Principal Areas of Disagreement Summary Statement (PADSS)

This statement has been prepared by Horsham District Council (“the Council”) with input from the joint local authorities, technical consultants and legal specialists. The Northern Runway Project application was submitted to the Planning Inspectorate on 6 July 2023 and accepted for Examination on 3 August 2023. The Council is one of the local authorities identified by Section 43(2) of the Planning Act 2008 and in response to the Examining Authority’s Procedural Decision letter of 8 September 2023 to the Applicant and the Host and Neighbouring Authorities, the Council has prepared this Principal Areas of Disagreement Summary Statement (“PADSS”) (Version 1). This Statement identifies the initial principal areas of disagreement and is provided only as a summary position at this pre-examination stage. The Council appreciates this document is long; however, its length is a reflection of the scale of its major concerns with the application. In the light of these concerns, the Council considers the length of the document to be reasonable.

Diagram 3.3.1: Model performance before and after adjustment, Generic zone

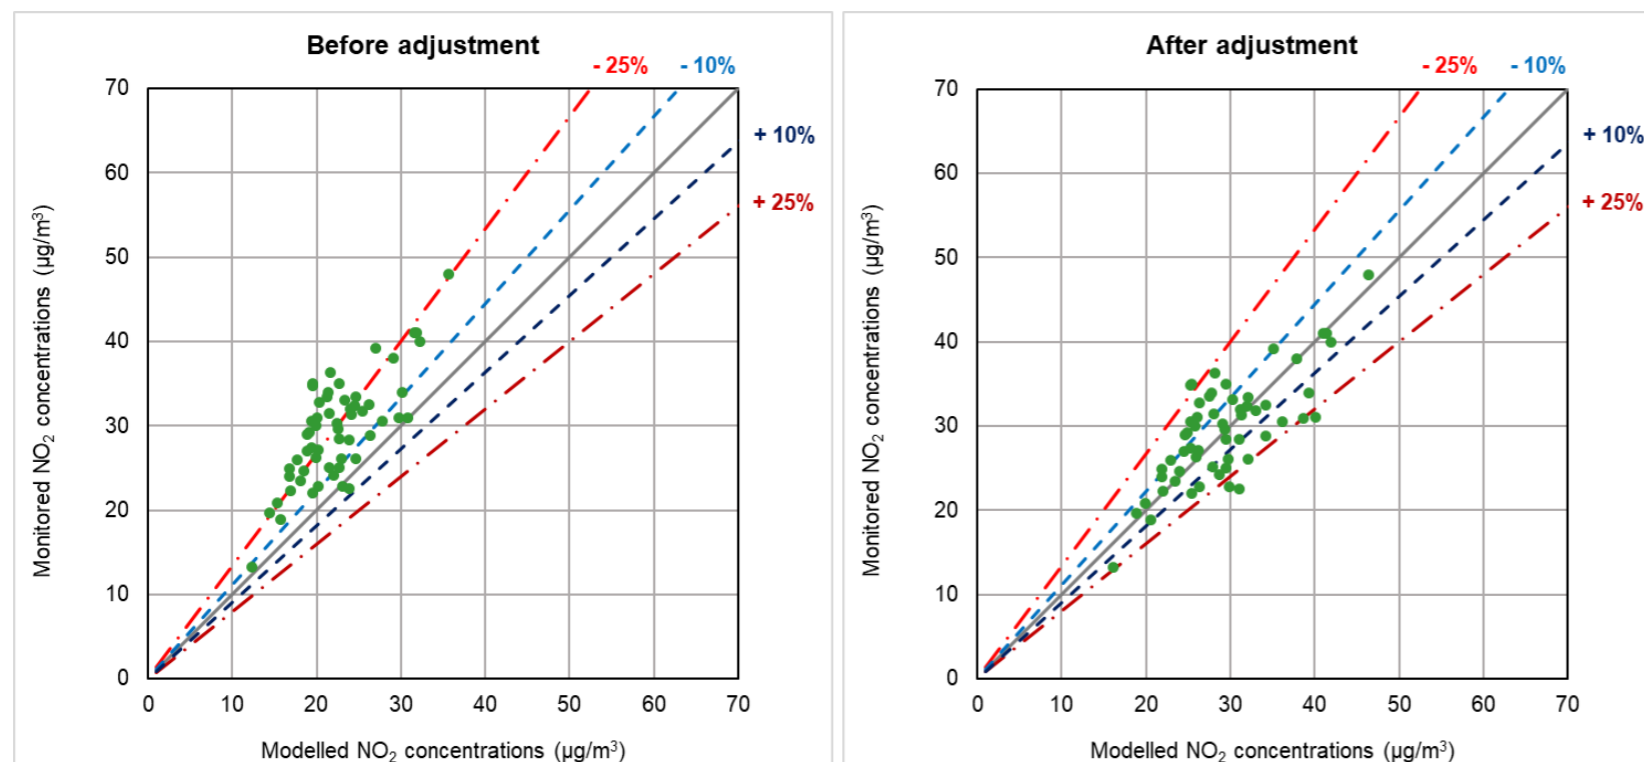
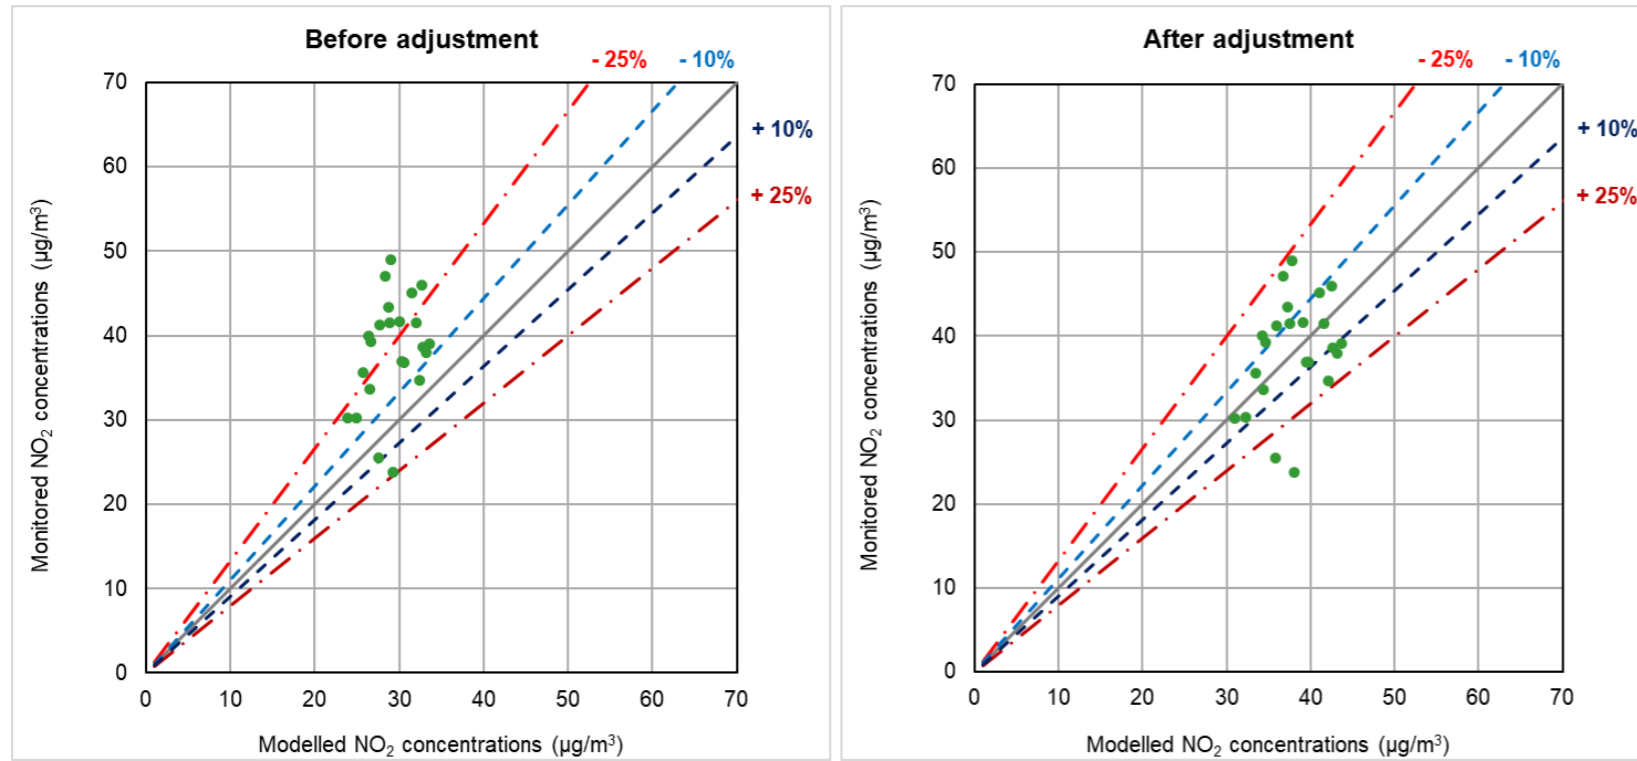
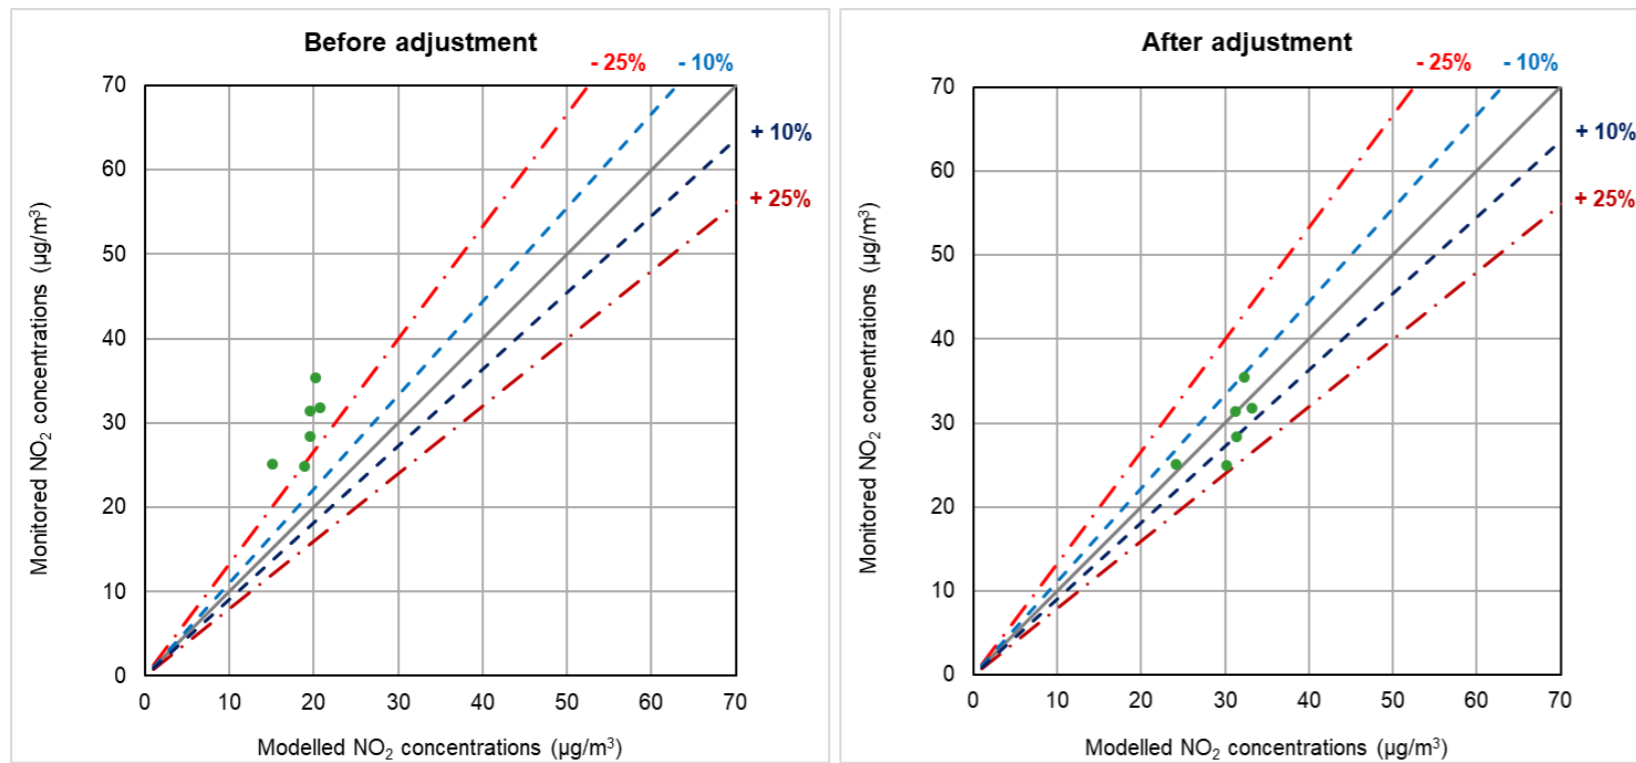
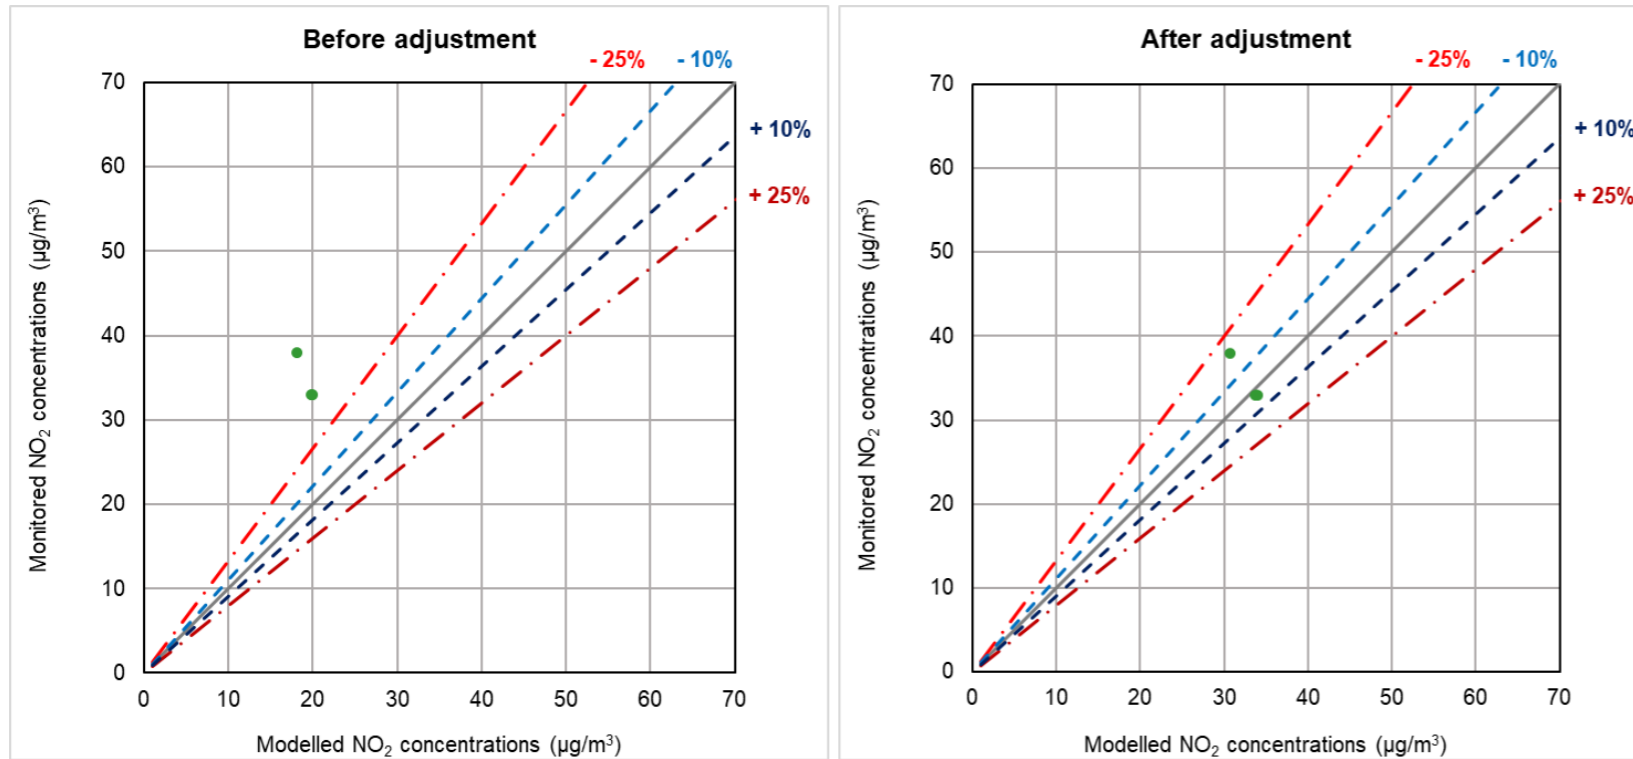
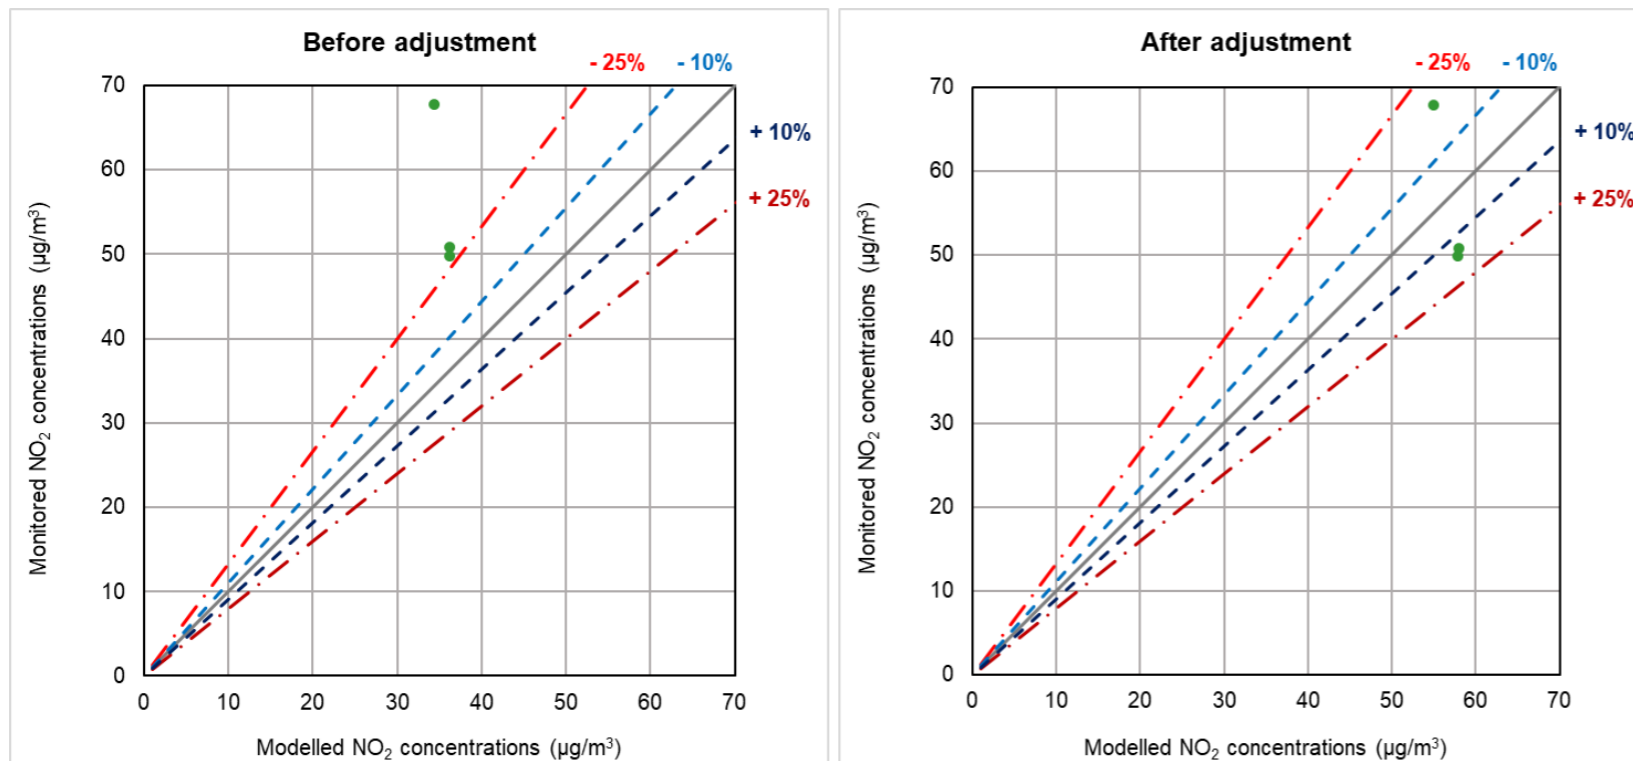
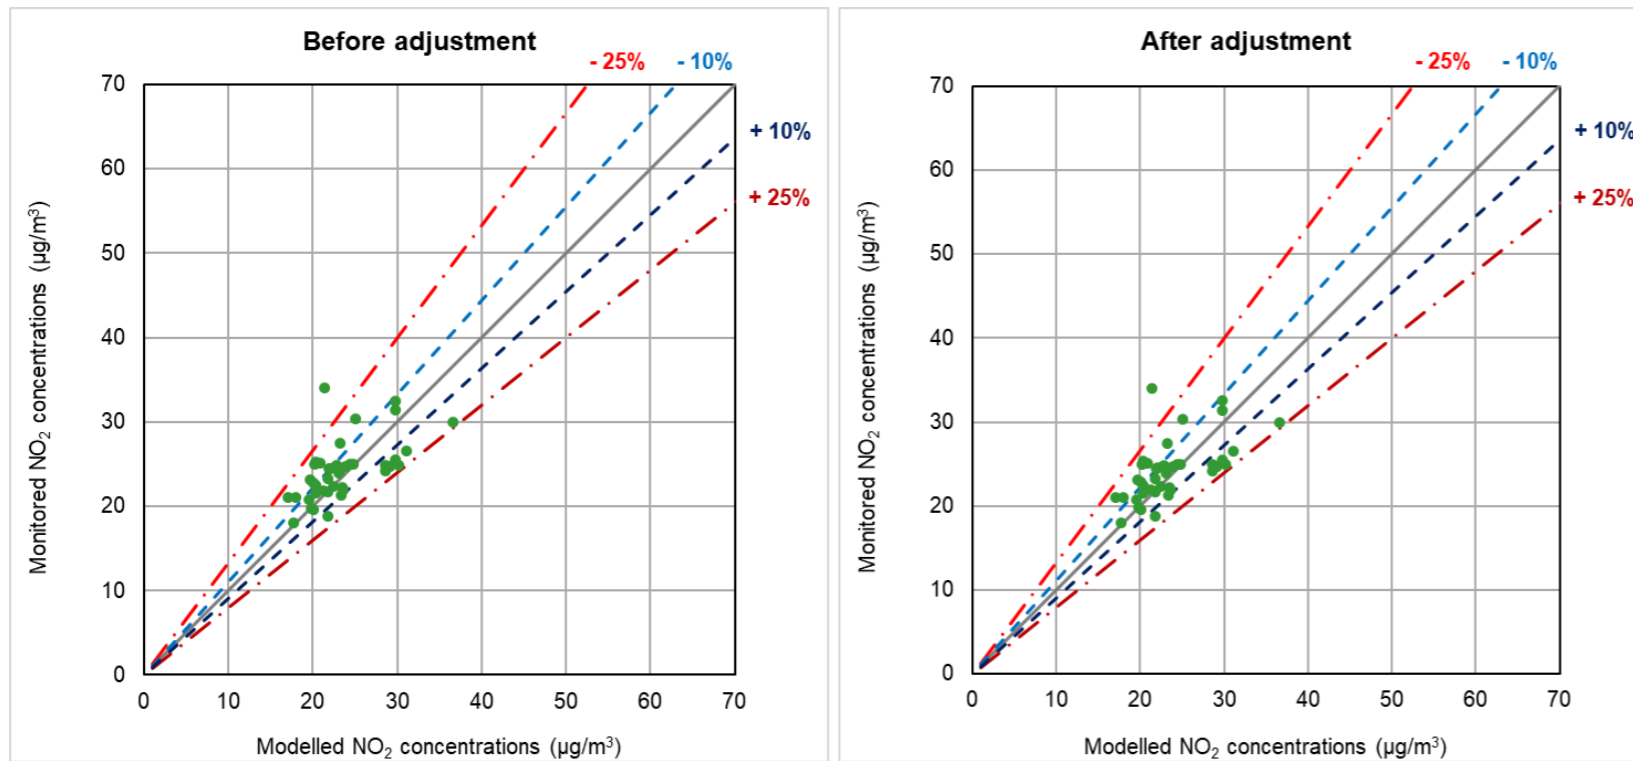
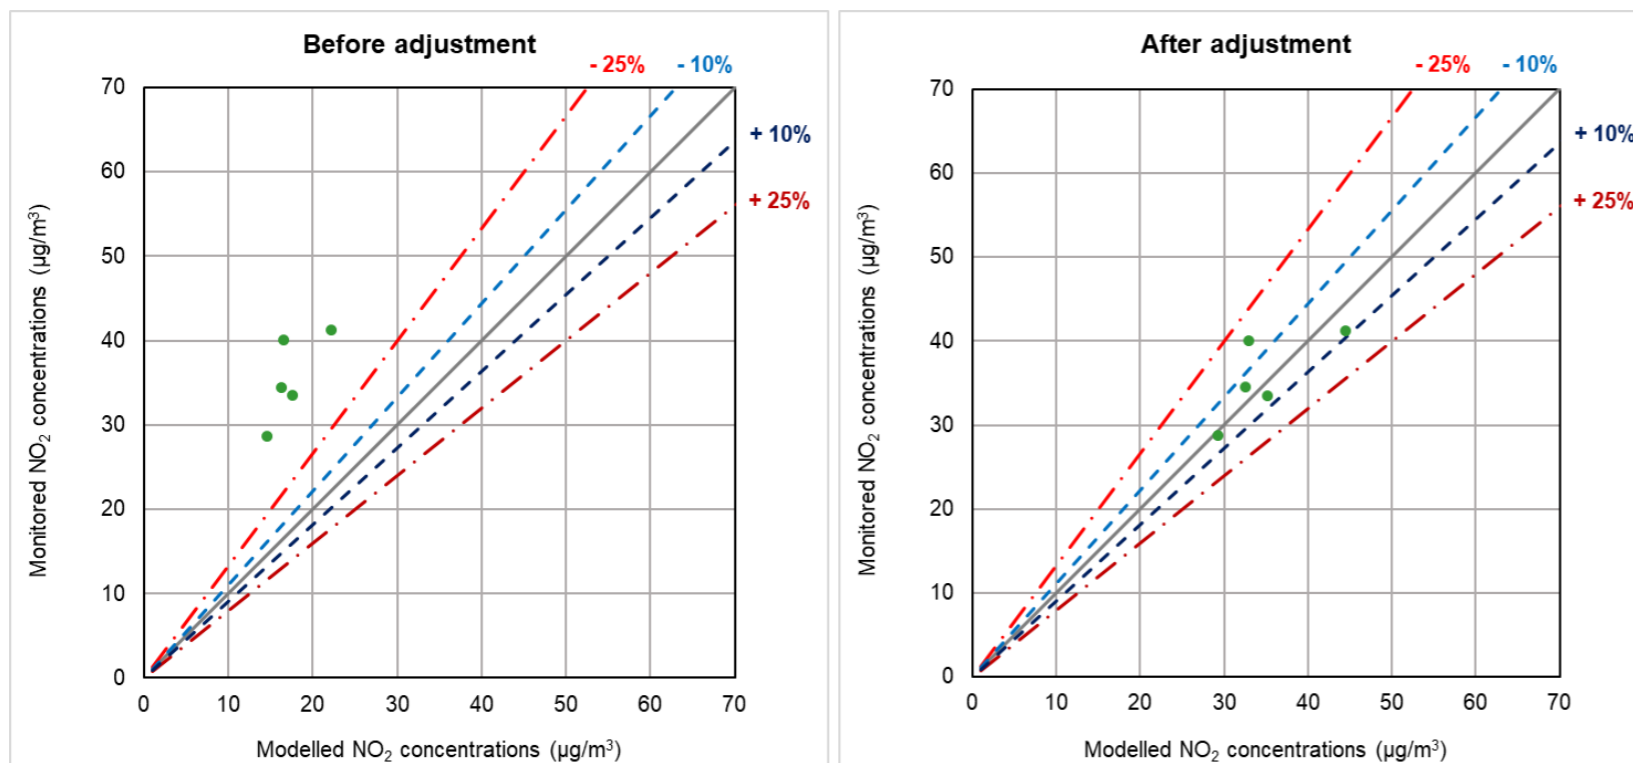
3.5	<p>Model Set Up and Methodology</p>	<p>Regarding model verification, Appendix 13.6.1: Air Quality Data and Model verification is missing details on how model verification factors for the selected zones were established. Details are required of the initial verification including Monitored Road NOx Contribution versus Unverified Modelled Road NOx, which monitoring sites were used, and which were removed from the verification process.</p> <p>To facilitate the scrutiny of the model set up and any assumptions used, it is requested that a complete set of input files be shared for 2018 (Base Year) and 2029 (nearest future year). In addition, Operational and Construction impacts for 2029 should be modelled jointly as one scenario,</p>	<p>The Applicant should provide further details in relation to the model verification</p>	Uncertain
